MDT-SKP22005-R1-SKP-redlines.pdf Markup Summary

Identify the classification of Vollmer Road (Minor Arterial) and identify the ROW width (100') per the proposed construction drawings of Vollmer Rd (PCD File: CDR2110)

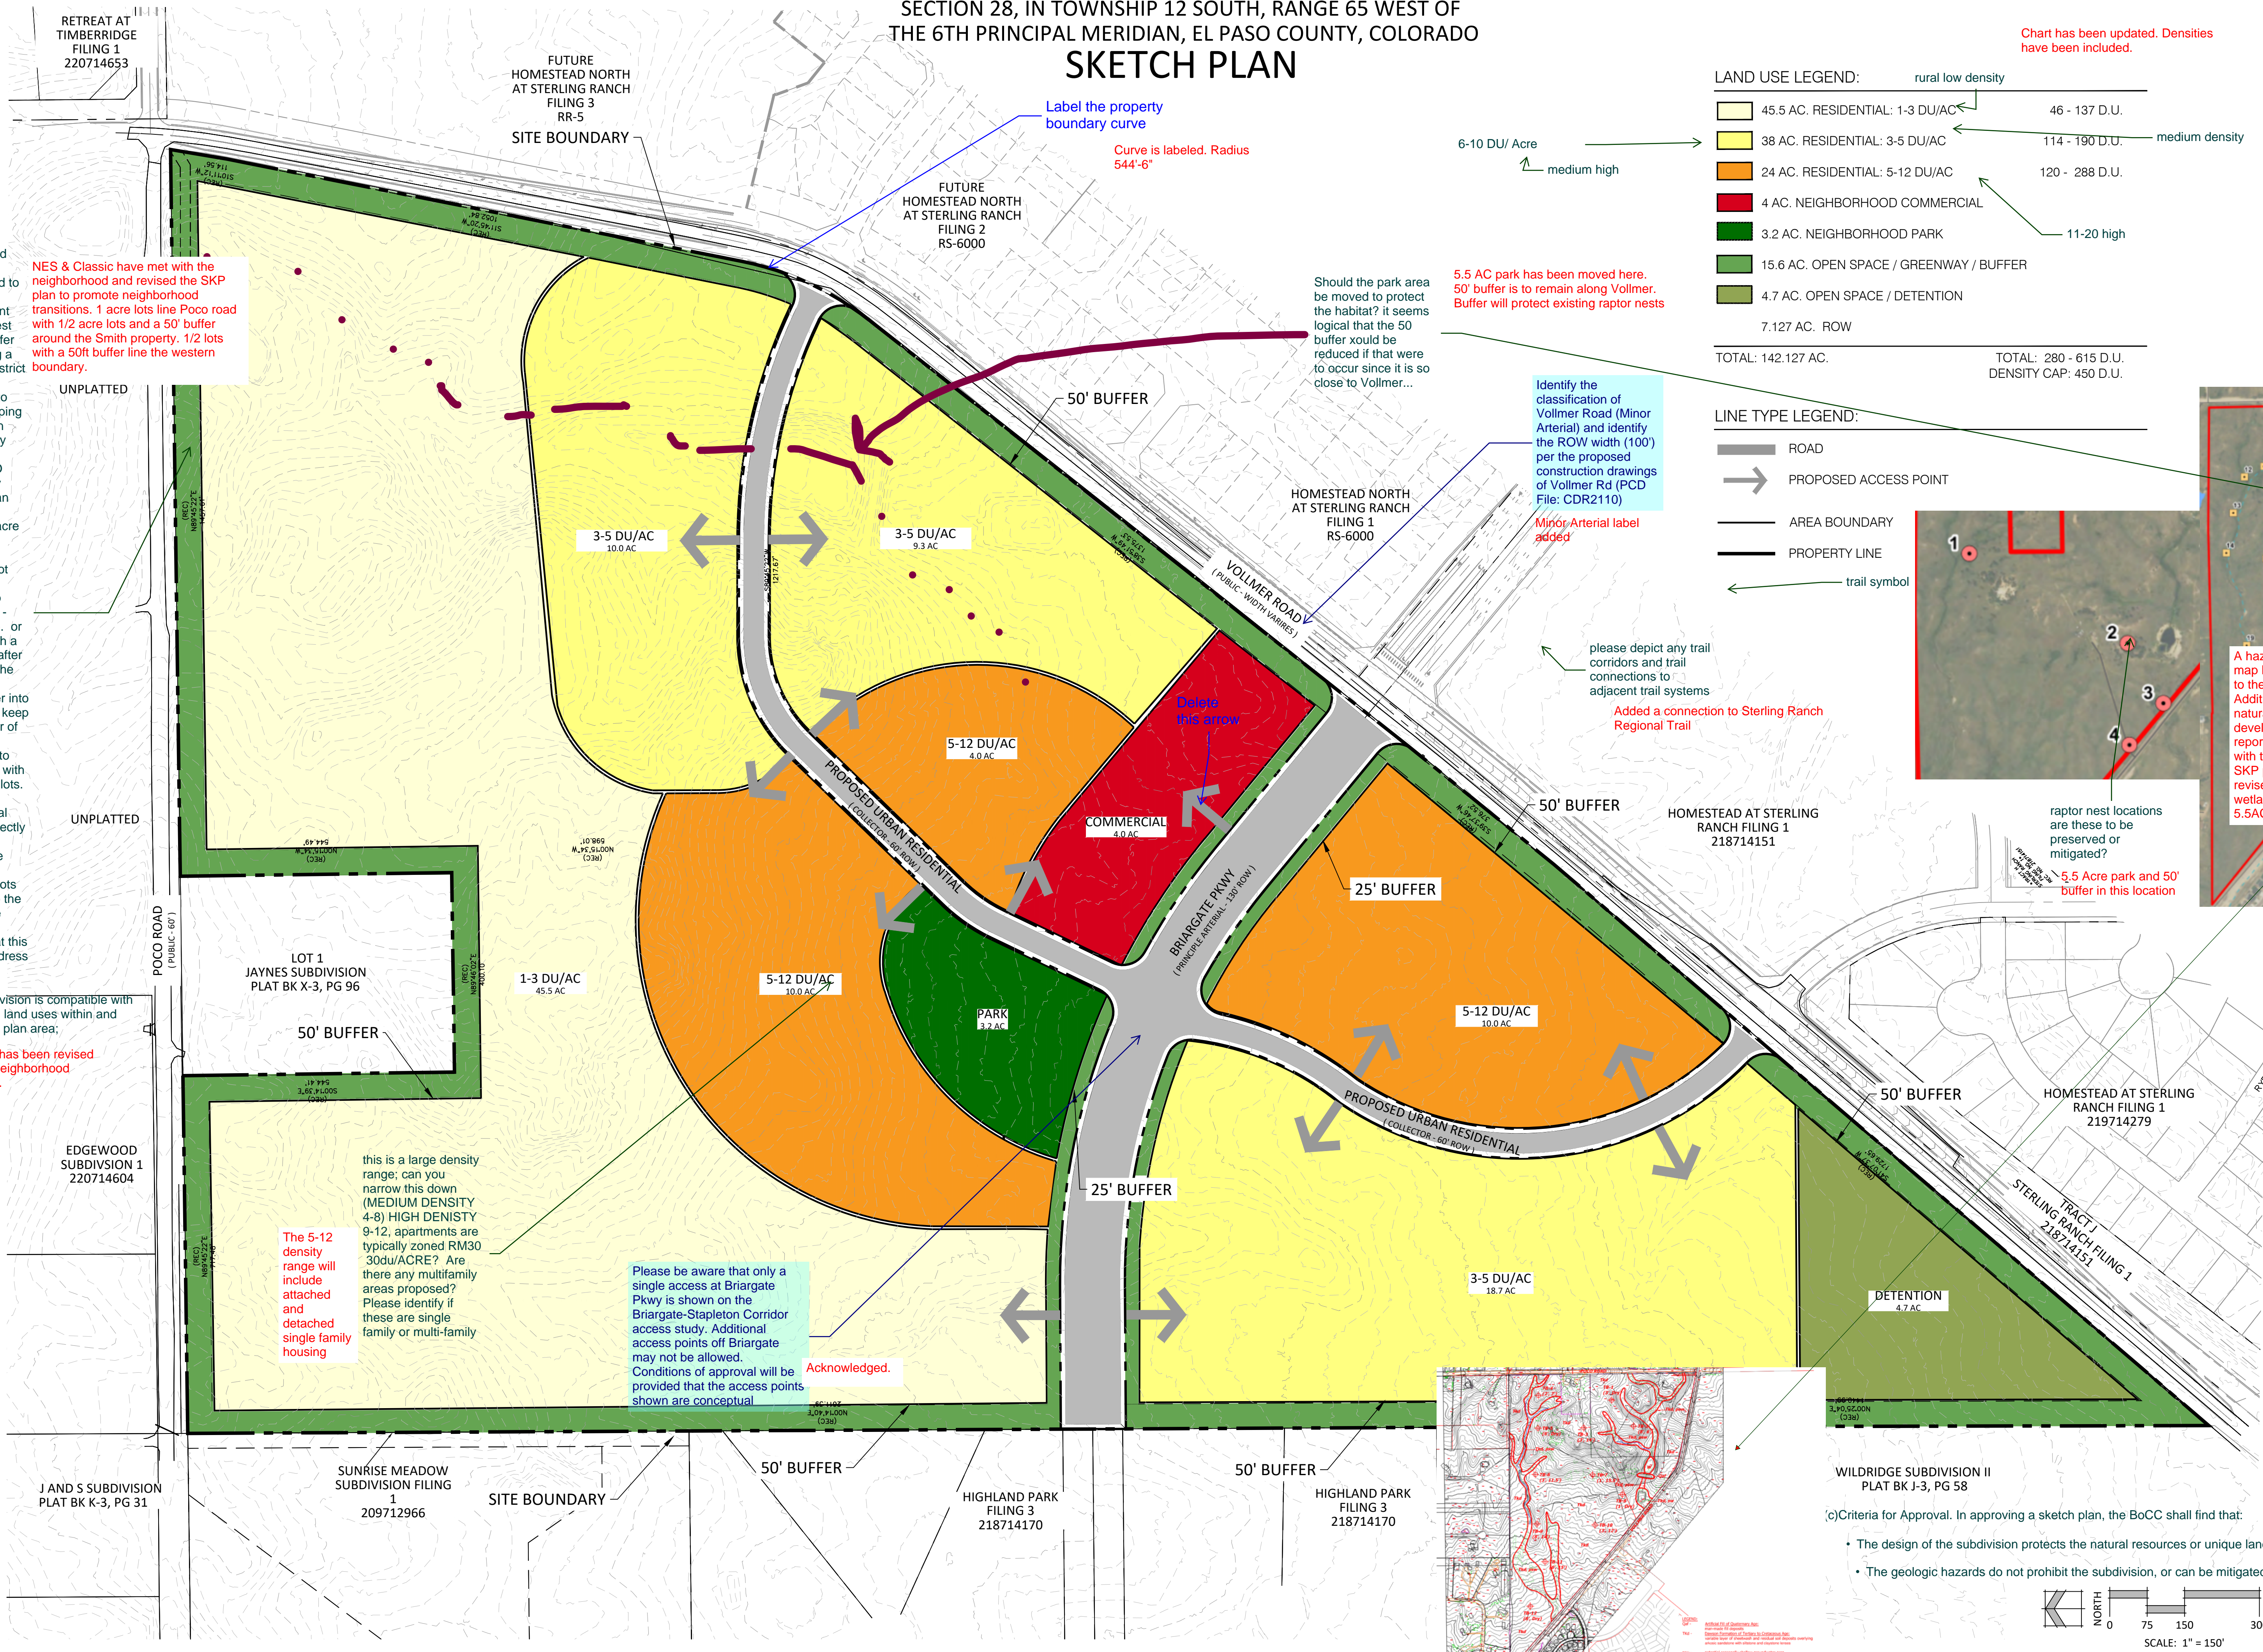
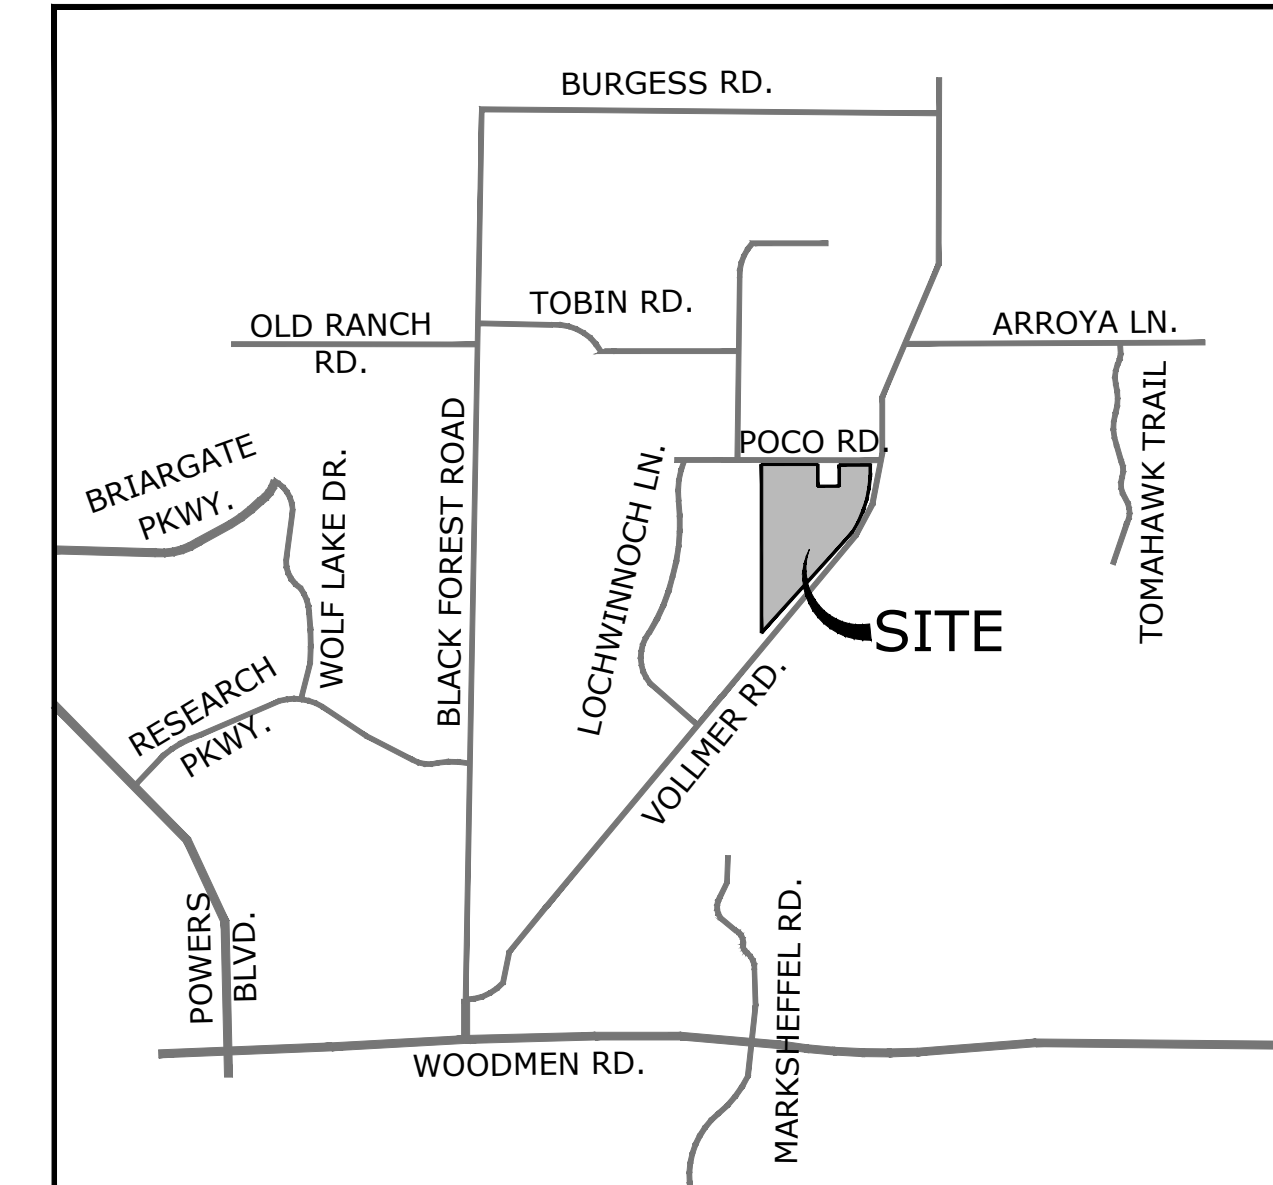
add widths of the ROW please

add "subject to change without a sketch plan amendment"

are anticipated to serve- strike will...(commitment letters are not required, just feasibility)

The Code has landscape standards

Add A note stating what the buffer minimums are for specific boundaries.

← are there any connection other than staples to existing roads?

Add note that streets and access shown are conceptual only and will be reviewed with subdivision applications.

2 OF 3

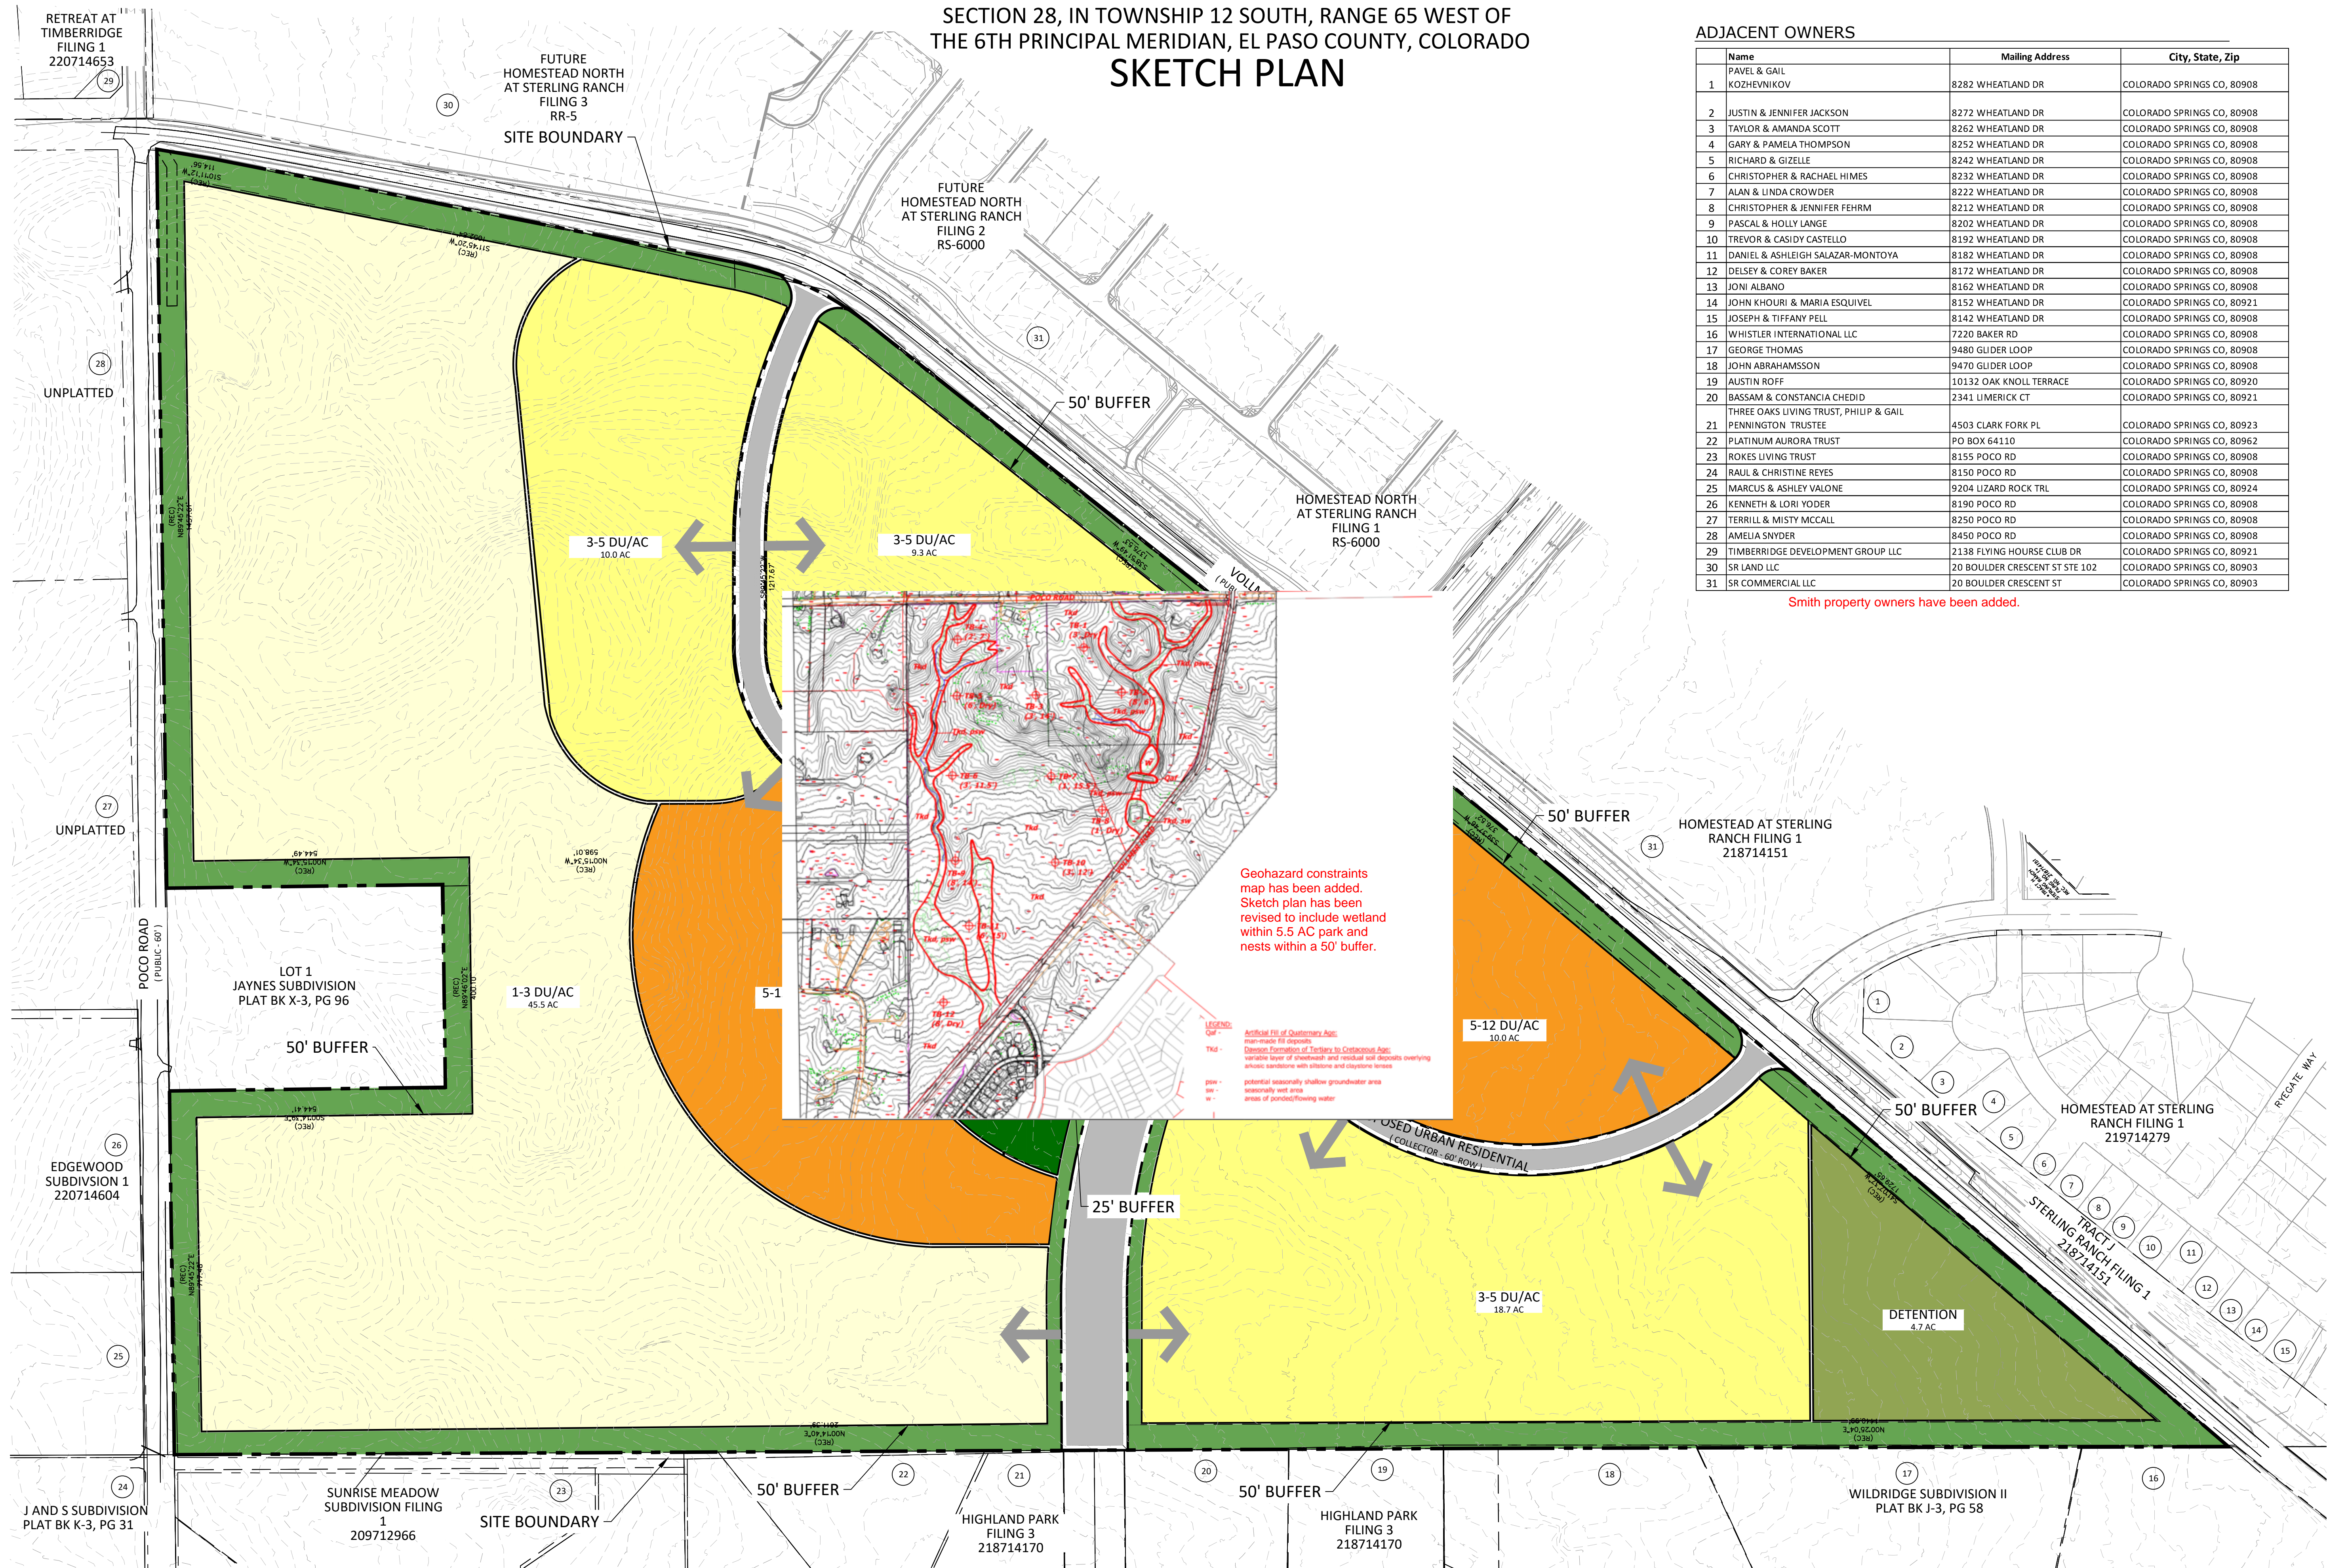
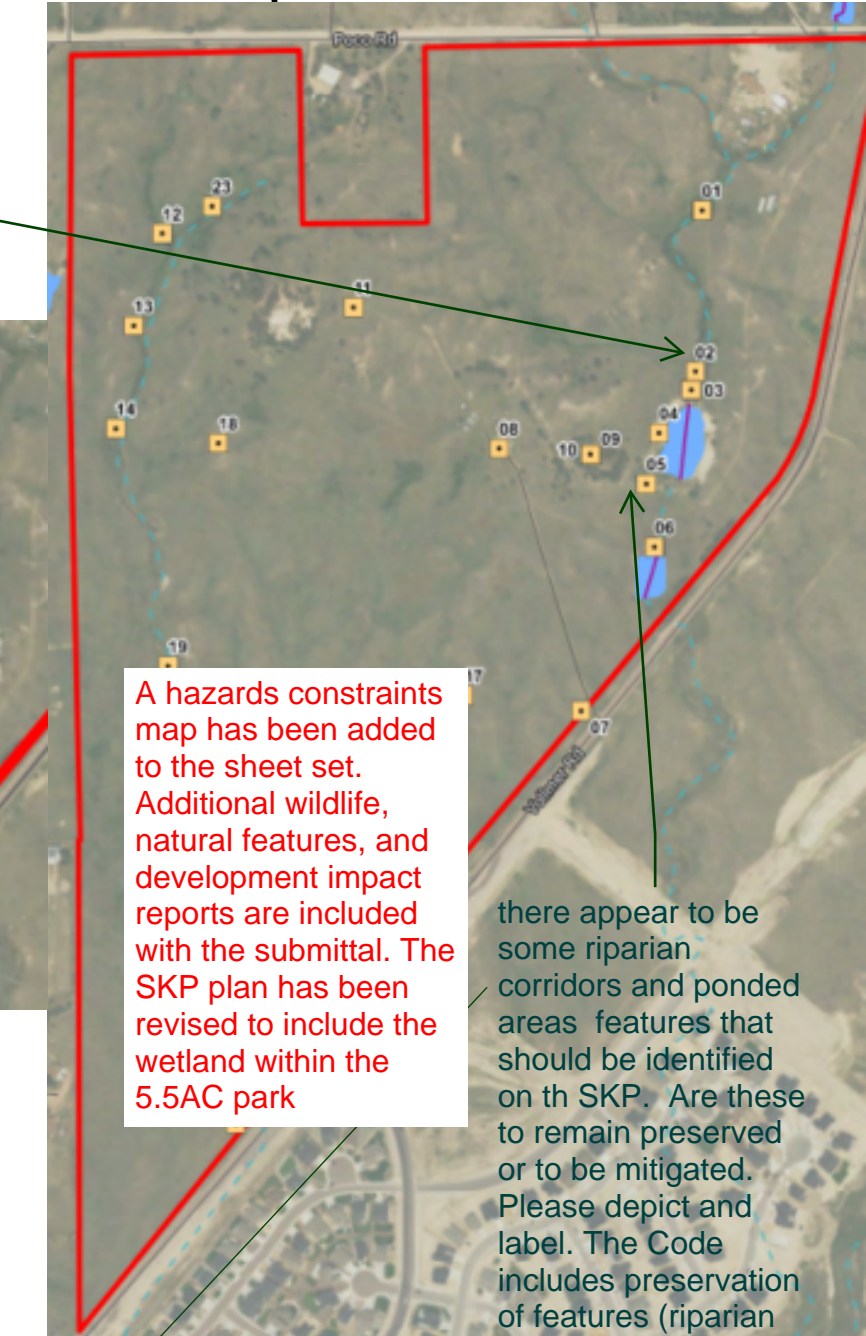
Staff has received over 50 letters of opposition related to urban density proposed adjacent RR5; Staff suggest removing the buffer tract, and placing a RR 2.5 zoning district (0.4DU/ac) immediately adj to POCO and wrapping adj to the RR5 on western boundary one row lots accessing POCO then immediately backing into urban lots; Where the existing RR 2.5 acre property is staff recommends committing to a lot size of 1 acre; reduced buffer to minimum 15 feet - RR0.5 acre zone. or half acre lots with a larger 25' buffer after the rural lots on the perimeter are established taper into higher density to keep the same number of units? This will address the use to use compatibility with rural lots to rural lots. There may be possibility for rural lots to access directly to POCO to more efficiently provide internal roads to serve the urban lots immediatly adj to the rural lots with the SKP area.- see criteria below that this would help to address

this is a large density range; can you narrow this down (MEDIUM DENSITY 4-8) HIGH DENISTY 9-12, apartments are typically zoned RM30 30du/ACRE? Are there any multifamily areas proposed? Please identify if these are single family or multi-family

please depict any trail corridors and trail connections to adjacent trail systems

there appear to be some riparian corridors and ponded areas features that should be identified on th SKP. Are these to remain preserved or to be mitigated. Please depict and label. The Code includes preservation of features (riparian areas and raptor nesting areas) Chapter 8,

raptor nest locations are these to be preserved or mitigated?

Should the park area be moved to protect the habitat? it seems logical that the 50 buffer could be reduced if that were to occur since it is so close to Vollmer...

Please be aware that only a single access at Briargate Pkwy is shown on the Briargate-Stapleton Corridor access study. Additional access points off Briargate may not be allowed. Conditions of approval will be provided that the access points shown are conceptual

Label the property boundary curve

Delete this arrow
